From: Jenny
Sent: Tuesday, 20 January 2009 1:18 PM
To: 'kersten.tuckey@lands.nsw.gov.au'; 'patrick.dwyer@dpi.nsw.gov.au'; 'peter.ekert@environment.nsw.gov.au'; sally.munk@planning.nsw.gov.au; 'Stewart Brawley'
Cc: Robert Hanby; Lindsay McGavin; Sandy Pimm; 'Seth Philbrook'; John Sherwood
Subject: Major Project Application No. 08_0034 - Proposed Subdivision at Lots 2 and 3 DP 244652 Uriup Road Bilambil
Attachments: Layout Option 2.pdf; image002.gif; 17397D.PDF; PHOTO-1.jpg; PHOTO-2.jpg; PHOTO-3.jpg; PHOTO-4.jpg; RE: (DWS Doc No 1942807) FW: Major Project Application No. MP08_0034 - Bilambil Village

From: Keats Jon [Jon.Keats@environment.nsw.gov.au]
 Sent: Monday, 2 February 2009 8:54 AM
 To: Jenny
 Cc: Ekert Peter
 Subject: FW: Major Project Application No. 08_0034 - Proposed Subdivision at Lots 2 and 3 DP 244652 Urikup Road Bilambil

From: Kersten Tuckey [Kersten.Tuckey@lands.nsw.gov.au]
Sent: Monday, 2 February 2009 3:57 PM
To: Jenny
Subject: RE: Major Project Application No. 08_0034 - Proposed Subdivision at Lots 2 and 3 DP 244652 Urliup Road Bilambil

John Sherwood for
JACKSON INTERNATIONAL Pty Ltd
Bilambil Residential Estate
Bilambil Road Lots 2 & 3 DP 244652 BILAMBIL, NSW
LANDSCAPE CONCEPT PLAN
A1.DD.2 March 2009

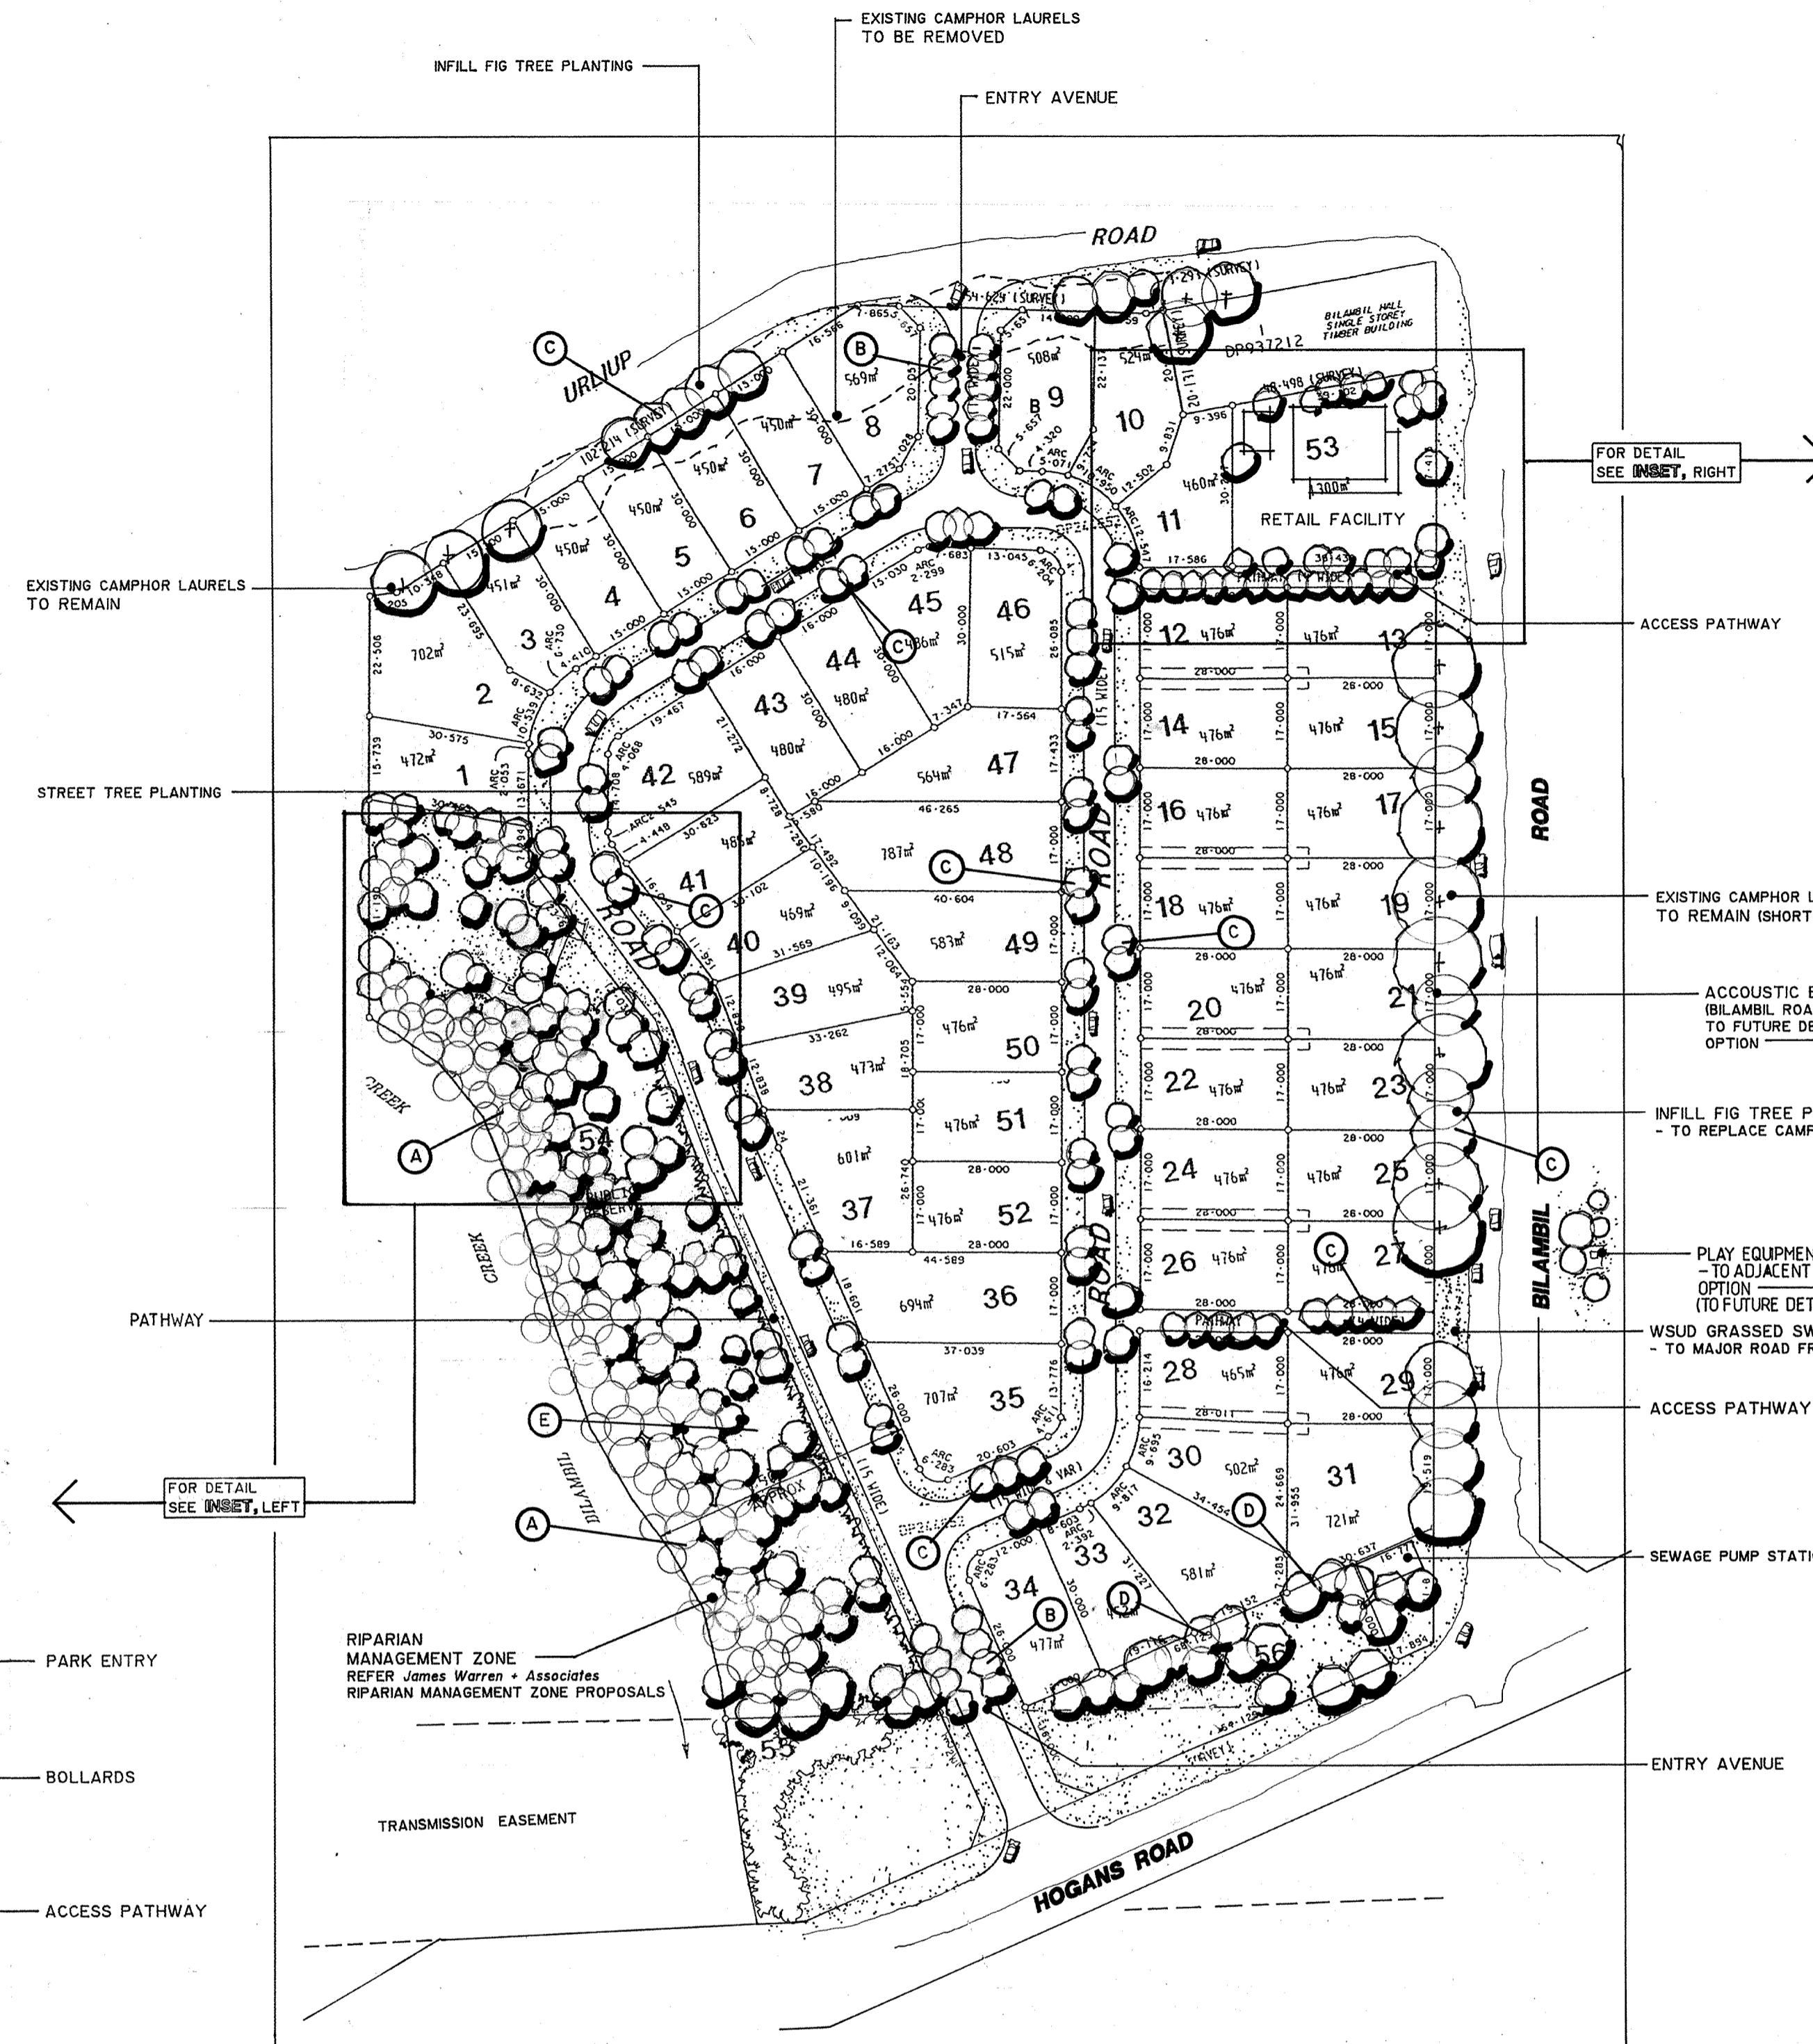
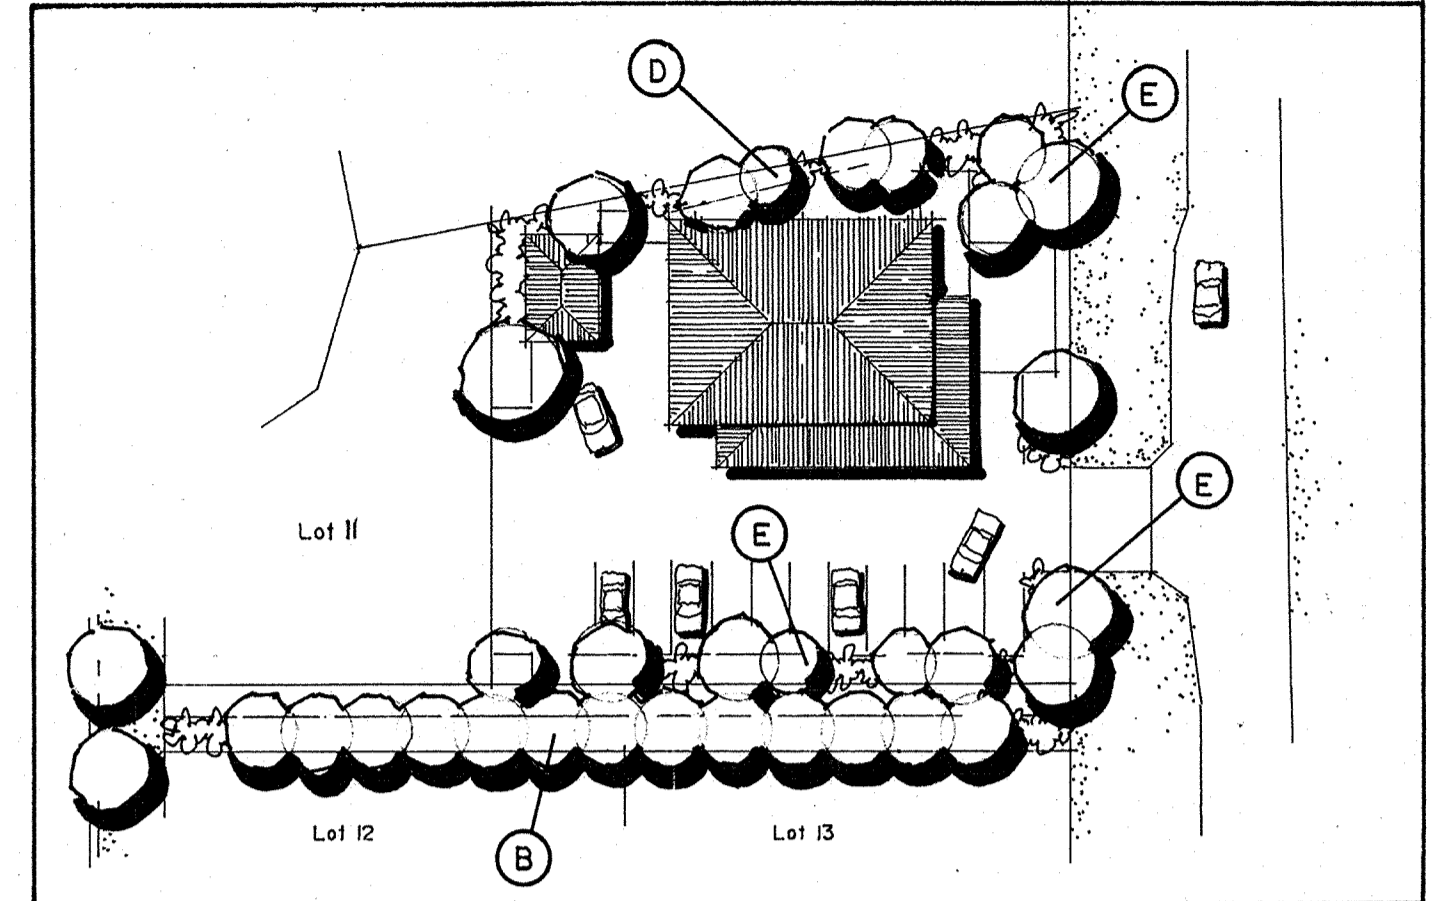
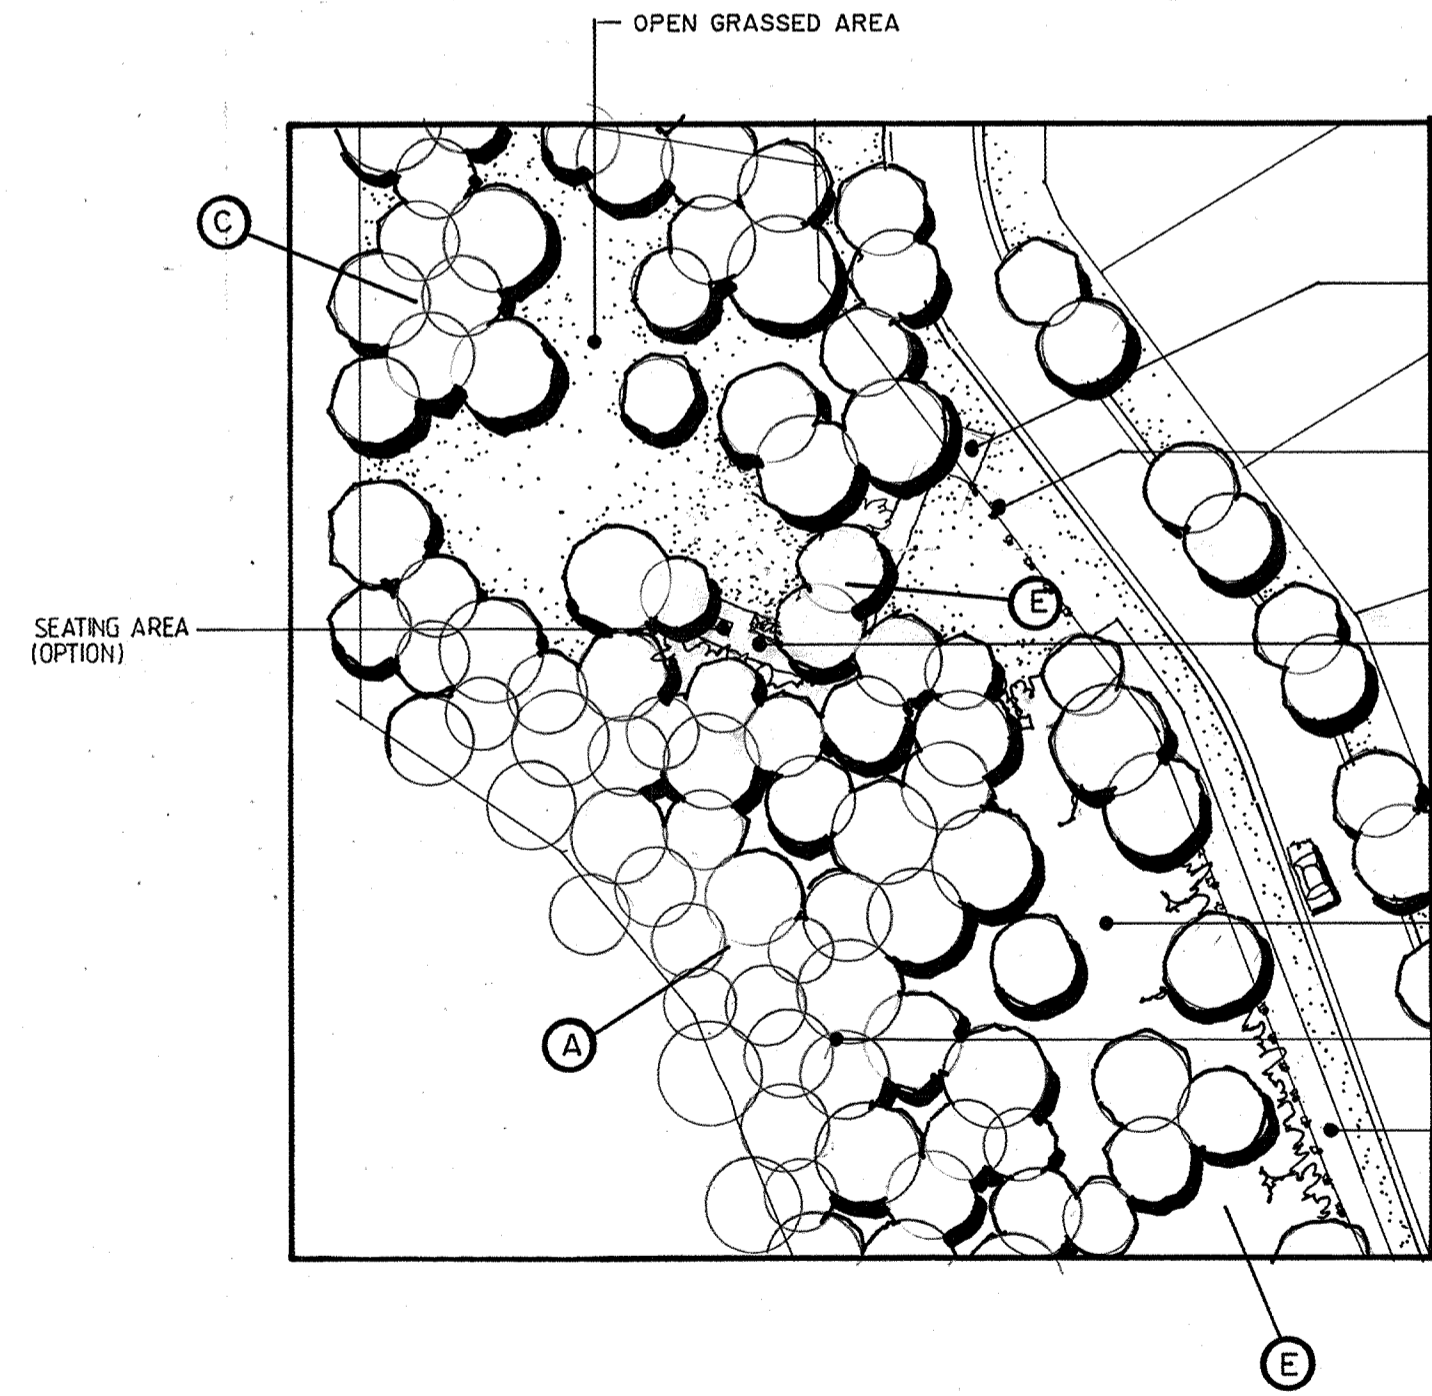
As per the telephone advice provided to John Sherwood, DECC acknowledges that the revised buffer proposal is more significant than the original, but it is still less than the DECC recommended configuration (of a 50 m vegetated buffer). It is likely that the proposed sealed road within the buffer would create issues with respect to potentially contaminated stormwater runoff and edge effects on the remaining buffer. Due to the increased level of pollutant runoff from hard surfaces and the increased velocity and quantity of surface runoff, DECC believes it preferable to locate the perimeter road outside of the recommended 50 metre buffer.

If the proponent prefers to retain the currently proposed buffer configuration, we recommend that the Environmental Assessment (EA) include a justification for that, including information to address the issues raised in the above.

Whilst the Department of Lands continues to support a 50m vegetated creek buffer it acknowledges that the amended subdivision plan is a significant improvement on the previous submitted plan and could provide a suitable buffer to Bilambil Creek provided appropriate revegetation strategies are incorporated. It is understood that the overall buffer from the lots to the creek would include the road and the revegetation area and would be approximately 50m in total. The placement of the road between the lots and the riparian revegetation area is also strongly supported as this will significantly reduce impacts on the revegetation area. Appropriate management of pedestrian access to Bilambil Creek from the casual open space area should be considered in the design of this area to prevent informal tracks becoming established and prevent erosion.
